Superior NW Enterprises

August 24, 2023

RE: Review of retaining wall plan for 6950 SE Maker, PN-9350900620

JOB NO. 22038
SHEET
C-2

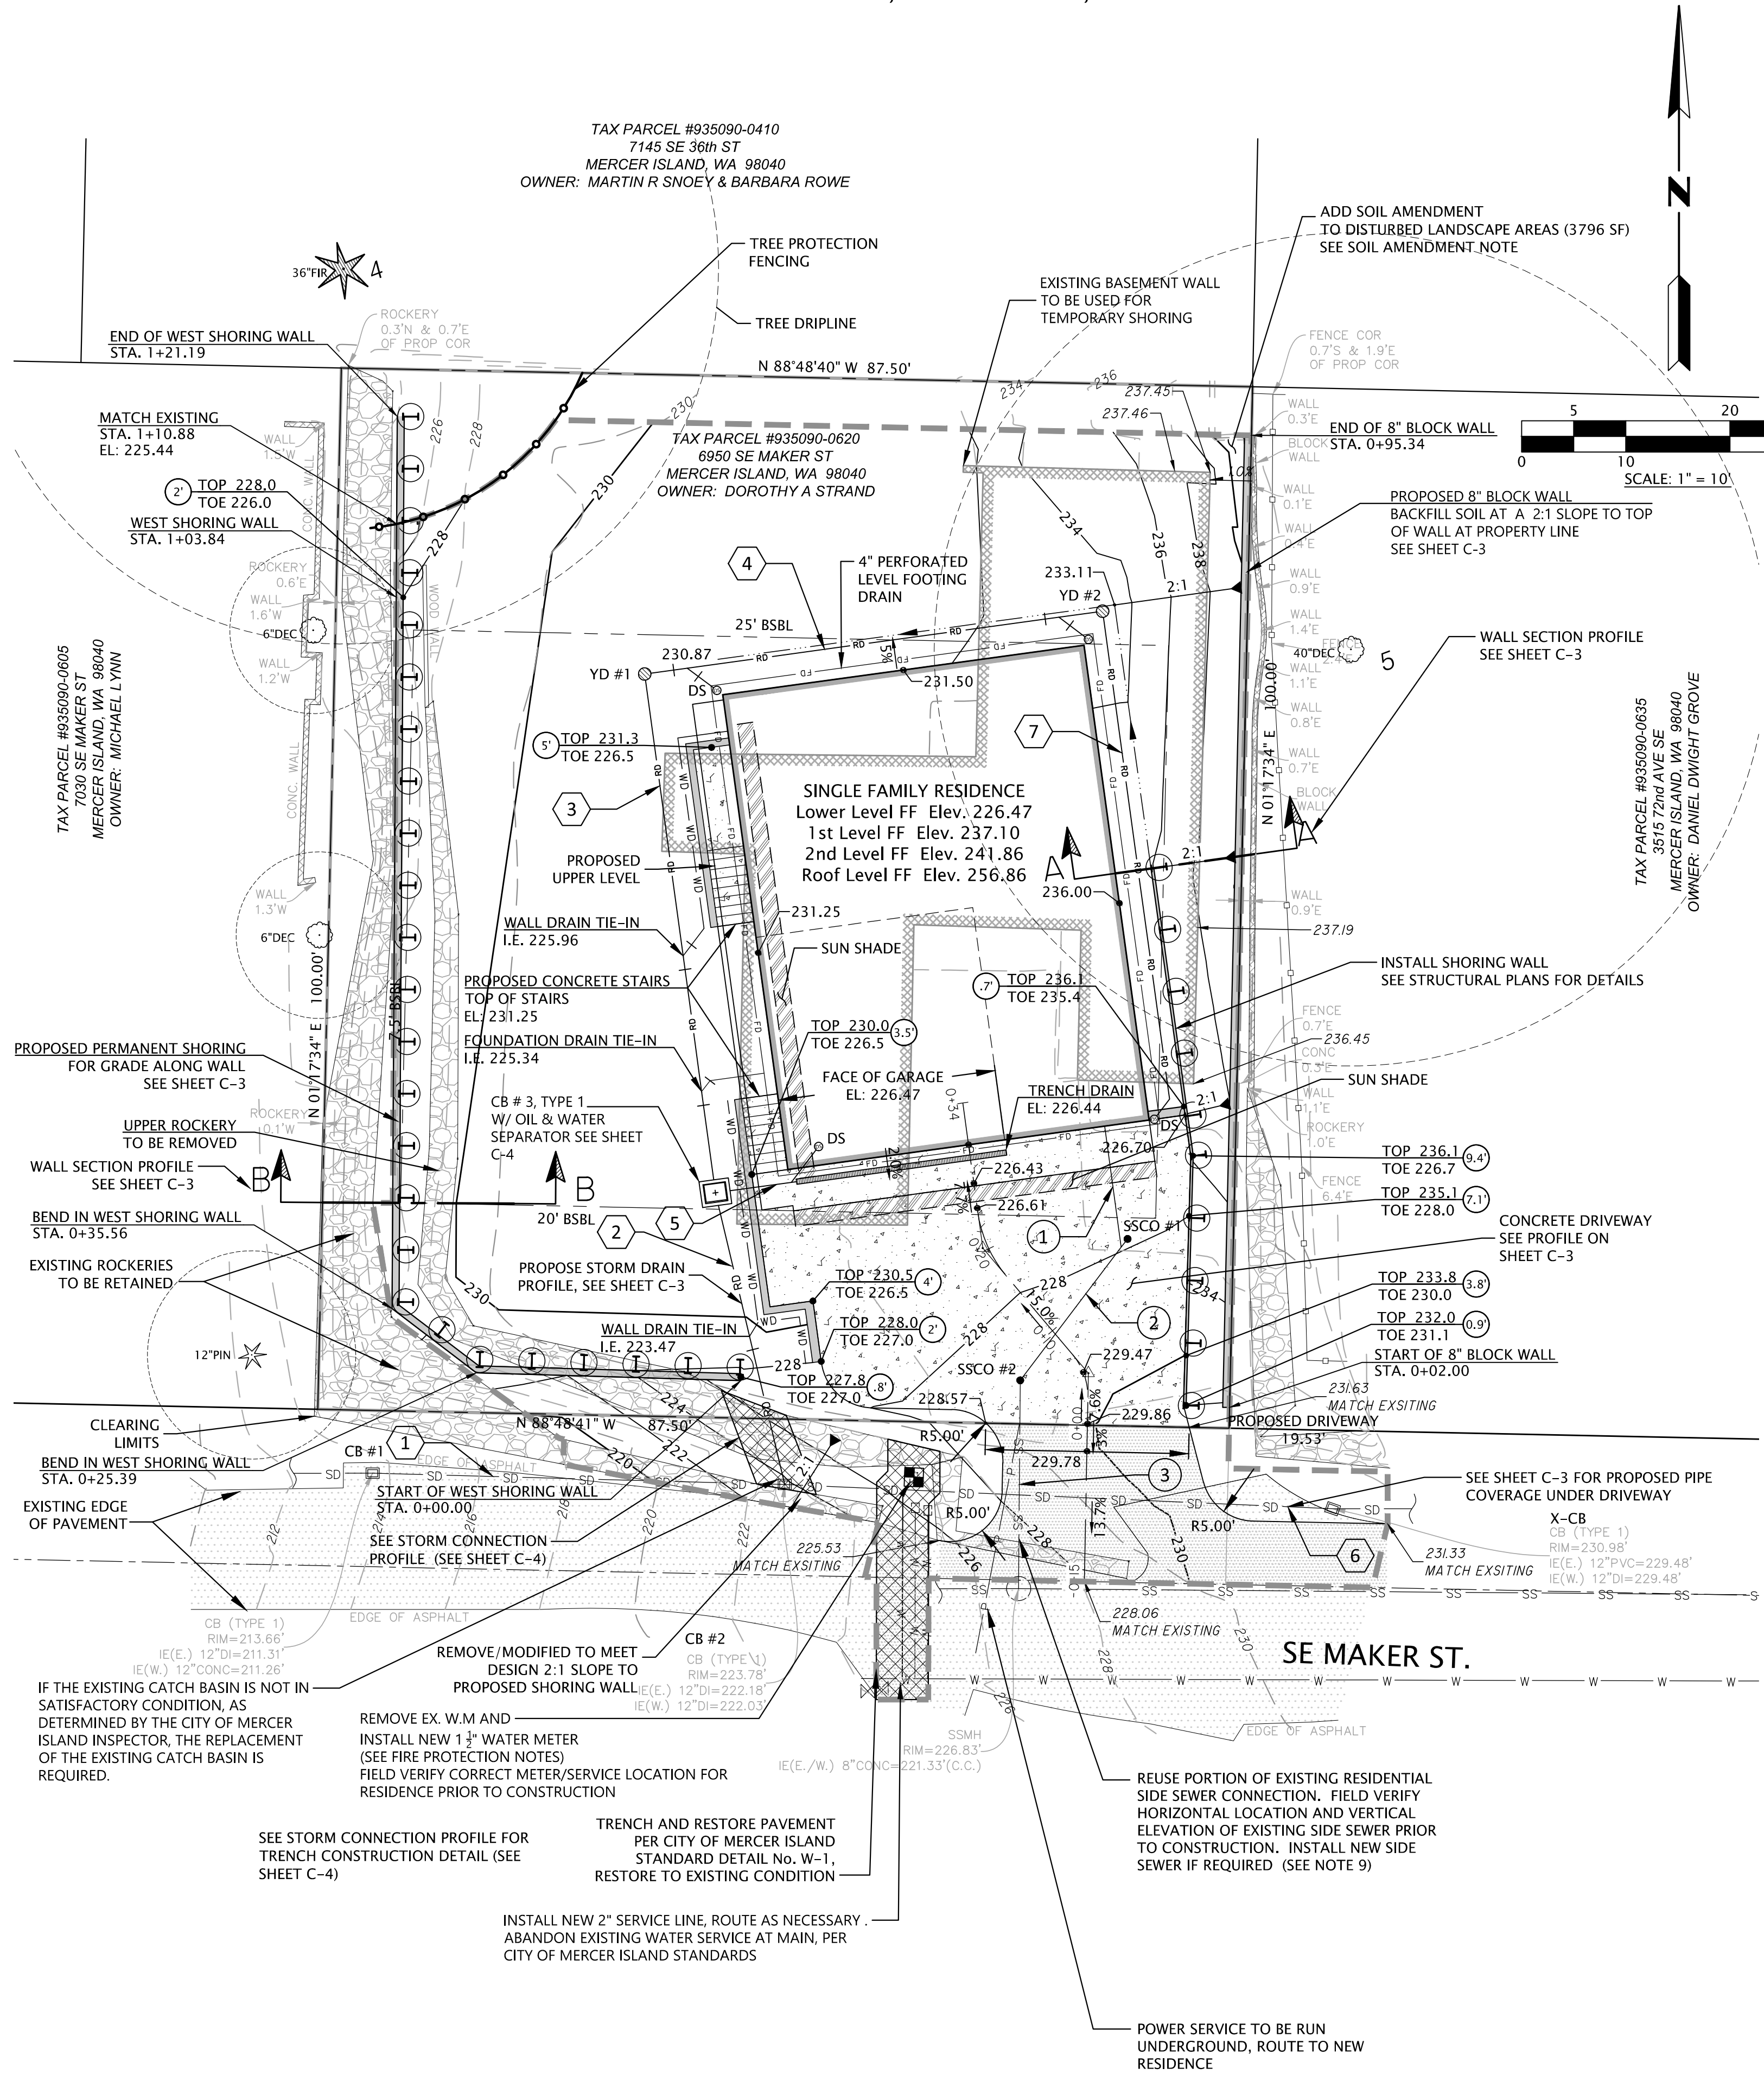
Initially no significant impacts were going to occur near the tree beyond the removal of the existing deck. However a geotech reviewing the proposed plan grew concerned with the existing rock retaining wall on the west side of the yard. He recommended that a pile and timber retaining system be installed to the east of the existing one. This work will theoretically cross into the CRZ of the big offsite fir.

Based on the plan set drawing shown in Figure 1 the north end of the new wall will terminate 15' out from the base of the tree. This means there is no chance that the work will damage the Structural Root Plate of the tree.

The base of the #4 tree is close to 5' below the level of *the base* of the existing stone wall which ends right at the NW corner post. According to the architect and builder this wall will remain in place and not be disturbed. Only a secondary section of stone that is well outside the theoretical CRZ will be removed to facilitate the installation of the pile wall.

The work plan states that the machinery required for drilling the pile holes will be stationed outside the theoretical CRZ for the tree. This is not absolutely necessary as it is highly unlikely that the fir has any roots present east of the existing wall in the first place. Douglas fir rarely has roots present below 36" due to compaction and oxygenation constraints.

In this specific case the tree is unlikely to have pushed roots around the wall and upslope into the subject property as there is not a resource base present that would have drawn roots into the space. Drilling the line of five 24" diameter holes within the theoretical CRZ would realistically create little functional impact even if the tree did have roots present in the space. They move perpendicularly away from the tree and have exponentially lessor chances of intersecting with any roots that may present.

Installing another wall 4-5' E and nearly 5' higher on the grade will create no significant disturbance for the tree. No excavation will be done to the existing grade. There will be fill work done to level the grade but this will occur over only 6% of the tree's theoretical rooting space. Again, it is highly unlikely that the fir does have roots present in the area.

Out of an abundance of caution an arborist should be onsite during the proposed work.
